TOWN AND COUNTRY PLANNING ACT 1990 TREE WORKS IN A CONSERVATION AREA

Reference: H16-0208-19 **Date of Decision:** 9th April 2019
Applicant: Mr Nick Riches - Environment Agency
Coronation Channel
Childers South Drove
Four Ashes
Spalding Lincs
PE12 6BQ
Location: Coronation Channel River Side Of Arnold Smith Meadow Nature Reserve
Childers South Drove, Four Ashes Spalding
Description: Works to trees in Arnold Meadows Nature Reserve

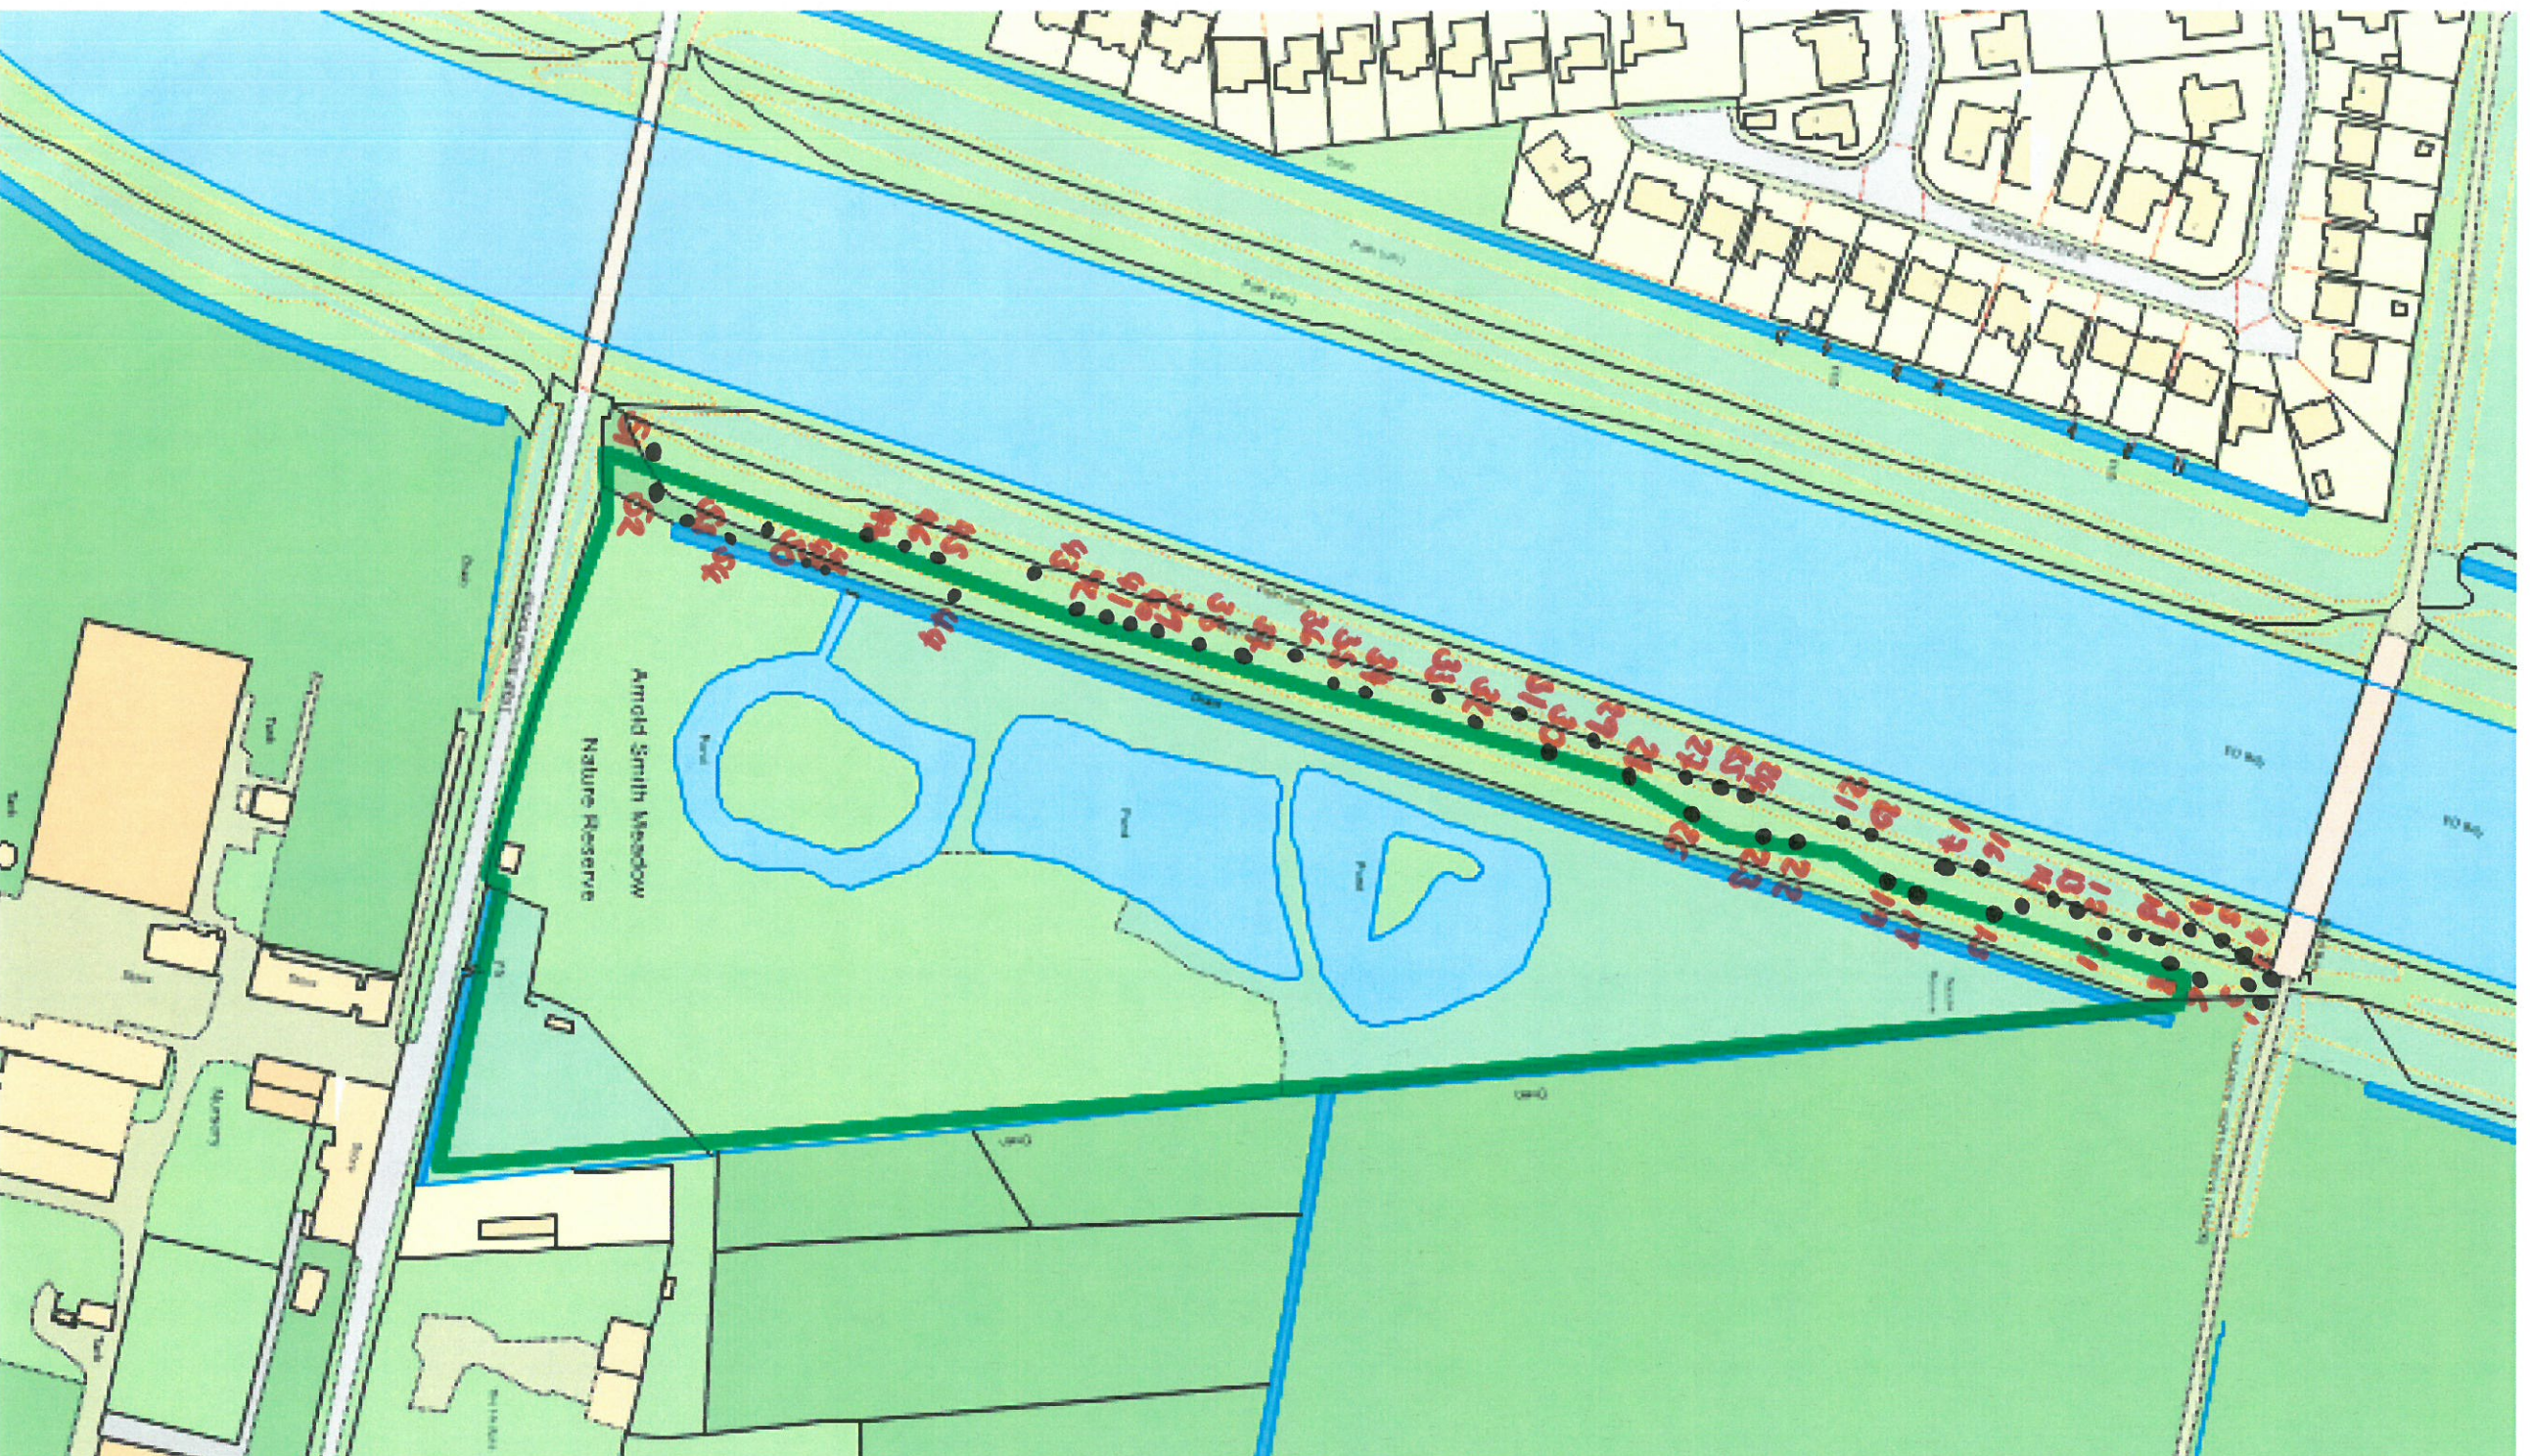
The map accompanying the Notification has a number of anomalies in it where the tree species and positions appear not to match what is currently on the ground. A walnut is present at the northern most point of the site where it is proposed to prune the trees.

Walnuts should only be pruned in late July and early August when they are in full leaf. If pruned at other times of the year a walnut tree can bleed sap profusely which can be very detrimental. If a walnut is still holding its leaves well, sometimes pruning can be carried out into September.

Silver birches should be pruned in late summer and autumn as bleeding of sap from pruning works can be a problem at other times of the year.

Pruning of sycamores should take place in late summer or early autumn. All pruning works to sycamores should be completed by mid-January to avoid problems of sap bleed.

Avoid pruning horse chestnuts in the spring months directly prior to and immediately after bud opening as bleeding of sap from pruning cuts may be a problem. Ideally horse chestnuts should be pruned between February and leaf fall. (A tree is present near the northern end of the site).

Pruning works to species of *Prunus* (cherry/plum) should be carried out after flowering but before mid-July, to discourage infection by the fungi known as silver leaf.

Other than the removal of dead wood lime trees should preferably be pruned in late July and August or alternatively in the autumn months. Avoid pruning from the end of January onwards, as the bleeding of sap may be a problem.
